Application no: **3/2021/0621**

Address: **Anagram Green Cottage West Lane Worston BB7 1QB**

Proposal: **Conversion of existing agricultural barn to a bunk barn with parking, access and storage (resubmission of application 3/2021/0115)**

The Local Highway Authority have viewed the plans and highway related documents and have the following comments to make:

DRAWING NO.	CAD REFERENCE NO.	REVISION
2002/JH/02		D

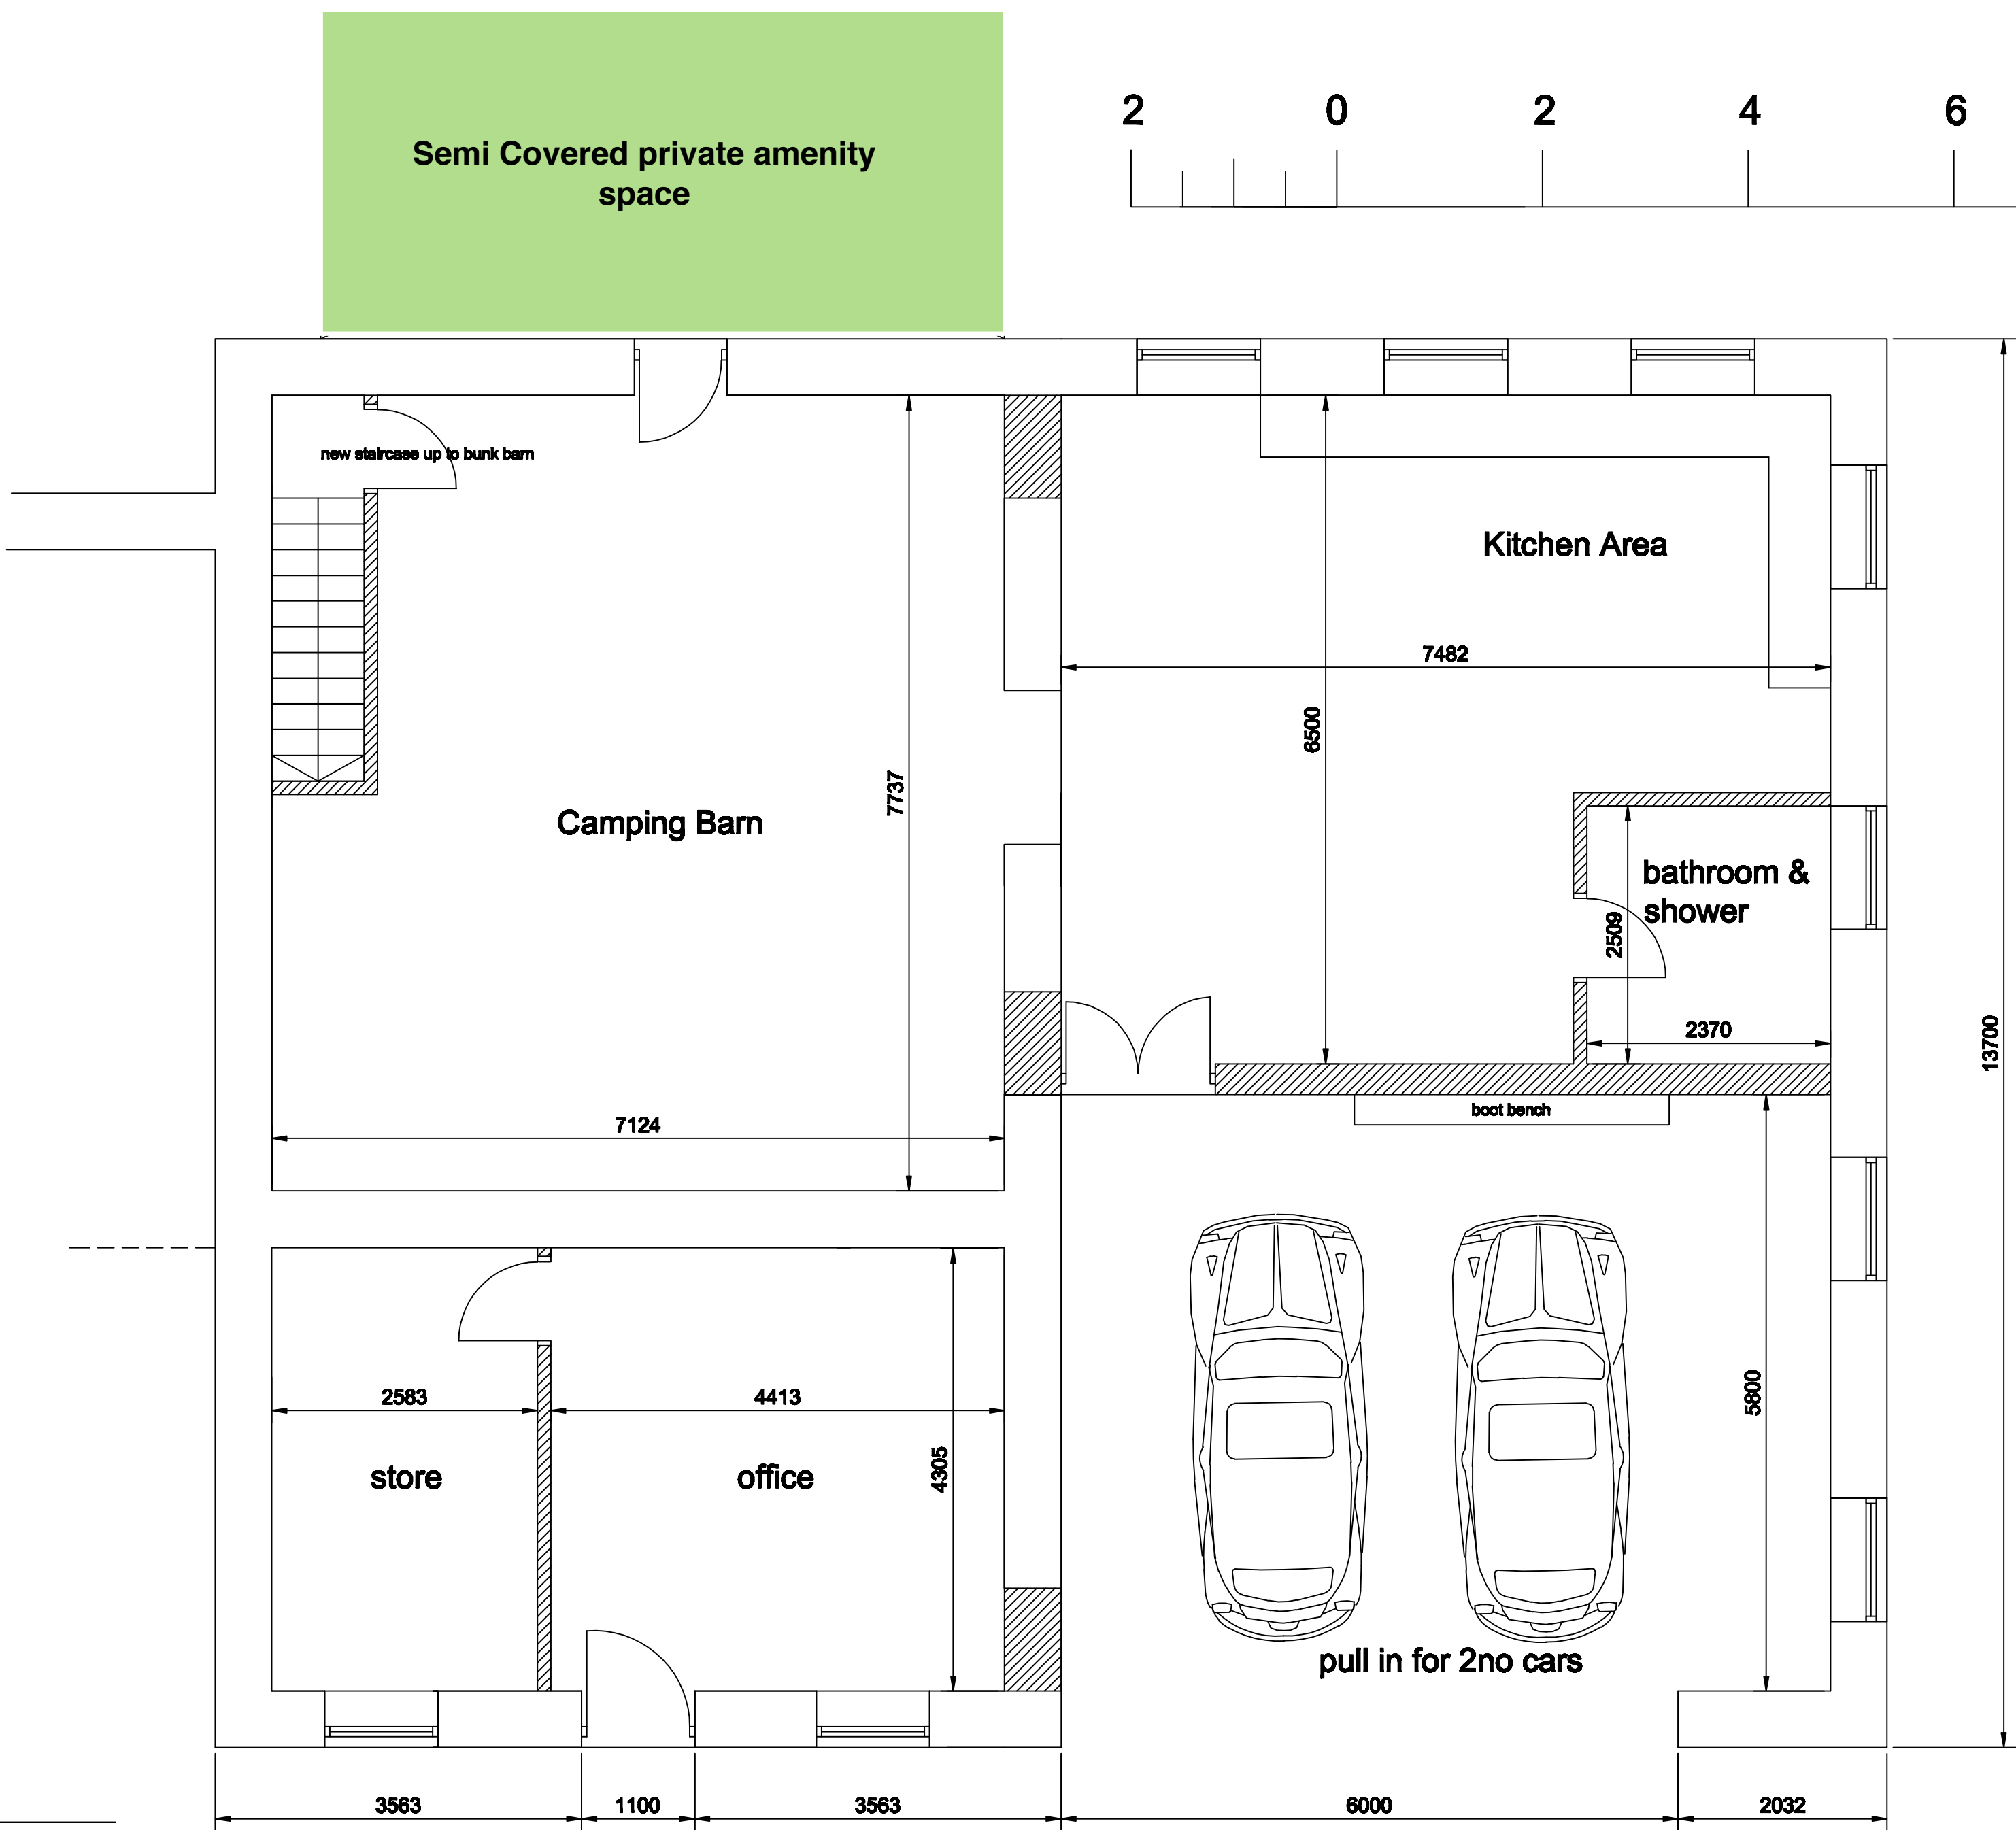
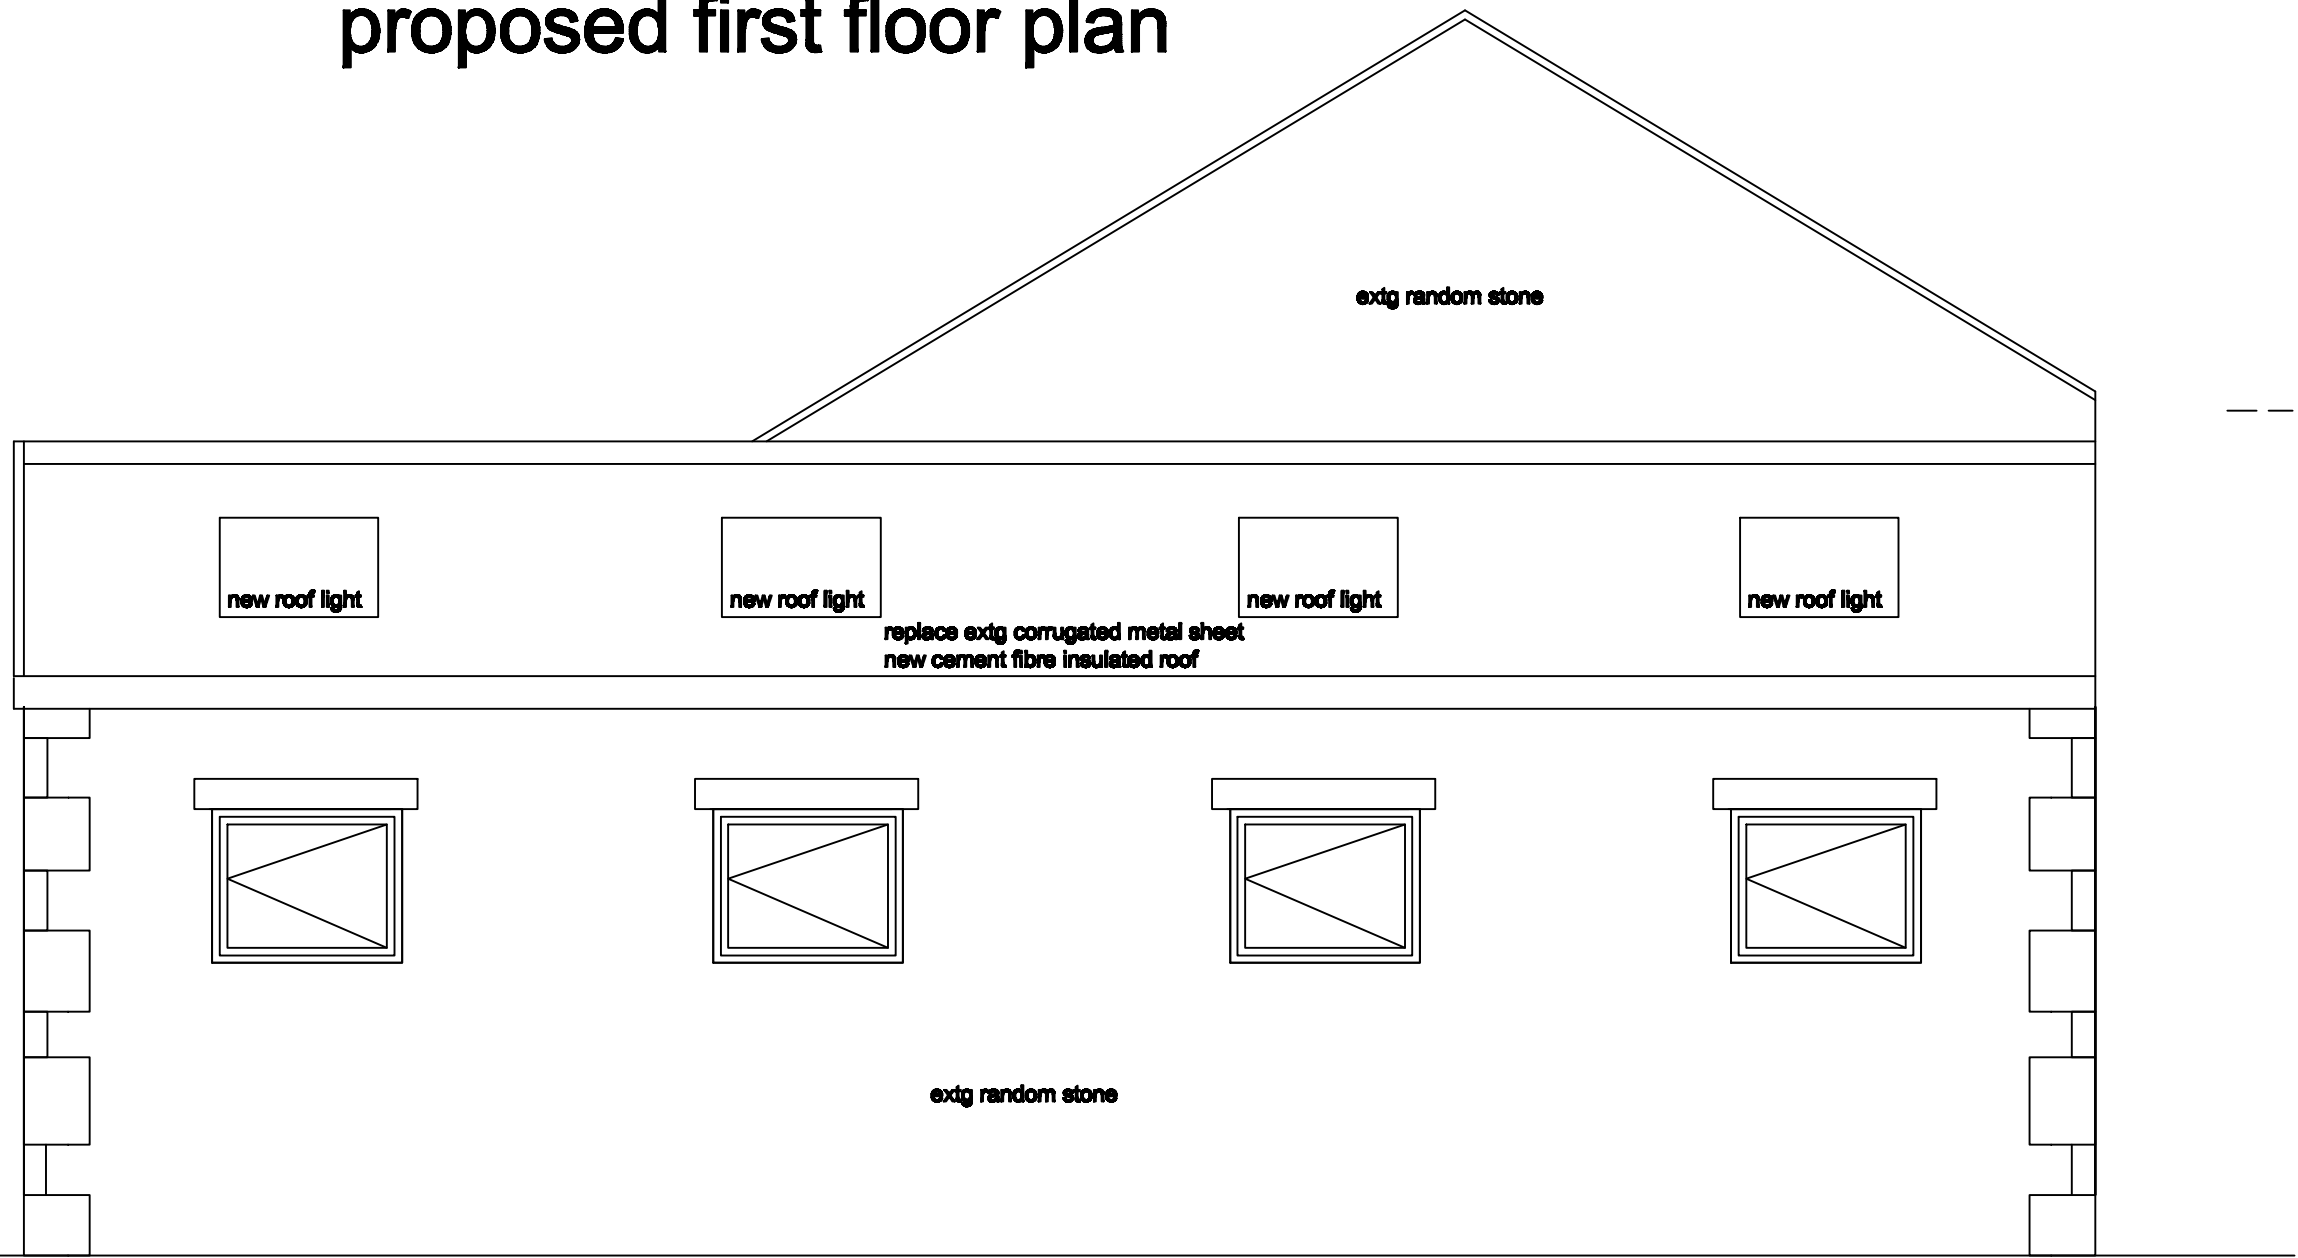
While the LHA are aware that the dimensions of the car port which are 6m x 5.8m as shown on drawing number 2002/JH/02 Rev D titled "Proposed Plans and Elevations" do not fully comply with the LHAs guidance. The LHA in this case will accept the shortfall with a double car port normal requiring to be 6m x 6m. Therefore, there is a minimal shortfall, and should 2 vehicles be unable to park in the car port, occupants of the barn will park elsewhere on site, a significant distance away from the public highway.

Site Location Plan 1:1250

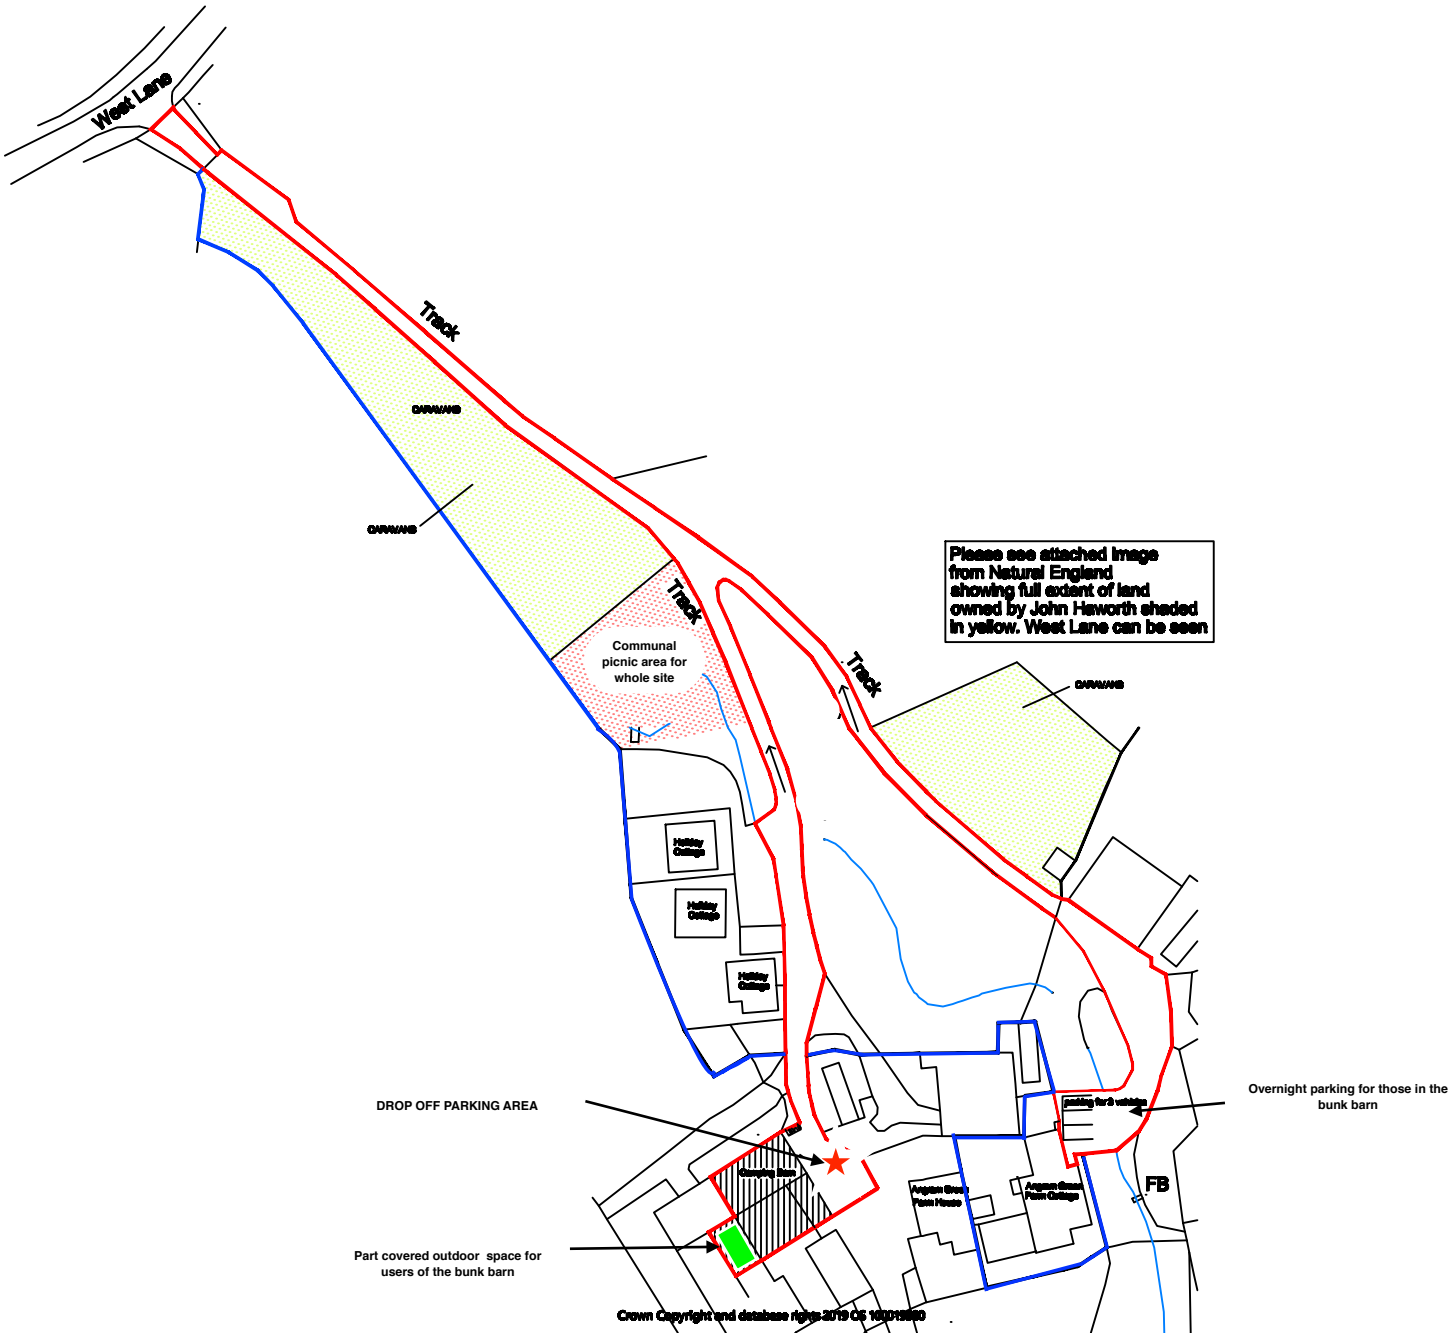
Therefore, with the same existing access being used for the same scheme following this proposal, as shown on drawing number 2002-S2P-A4 titled "Site Location Plan." The LHA are satisfied that should the surfacing be improved, the access will comply with the LHAs guidance.

The LHA have reviewed drawing number 2002-S2P-A4 titled "Site Location Plan" and understands the site will provide 5 car parking spaces for the proposal. 2 will be in the integral car port while 3 will be located in the area titled "Overnight parking" as shown on the drawing. As a result of 5 car parking spaces being available, the LHA are satisfied with the quantity of parking at the site.

The LHA are also aware that the "Overnight Parking" area is a distance away from the barn. The LHA would prefer parking to be located closer to the barn but understand the difficulties of this, with parking next to the barn potentially blocking movements to and from the existing farmhouse. Therefore, the LHA will accept the "Overnight Parking" area but advise the Applicant to erect signs around the access track to direct occupants of the barn to the area. Signs should also be erected to

direct the safe passage of pedestrians from the parking area to the barn. This is so potential pedestrians will not conflict with the operation of the site.

The LHA, finally advises the Applicant, to remove the "Drop off" parking area which is located outside the barn from the proposal. While the LHA understands that signs will be erected, informing customers that the area is only to be used for a maximum of 30 minutes, the LHA are concerned that customers will permanently park in this area. This will potentially obstruct vehicle movements from the existing farmhouse. Therefore, to prevent this site management issue from occurring, the LHA advise the Applicant to remove the area.

The LHA are aware that Public Footpath 3-48- FP10 runs adjacent to the proposed parking area, which is shown on drawing number 2002-S2P-A4 titled "Site Location Plan." Therefore, the LHA will place suitable conditions concerning the Public Footpath and advise the Applicant to consider the informatives below.

4. The development hereby permitted shall not be occupied until such time as the access drive (and any turning space) has been surfaced with tarmacadam, or similar

hard bound material (not loose aggregate) for a distance of at least 5 metres behind the highway boundary and, once provided, shall be so maintained in perpetuity.
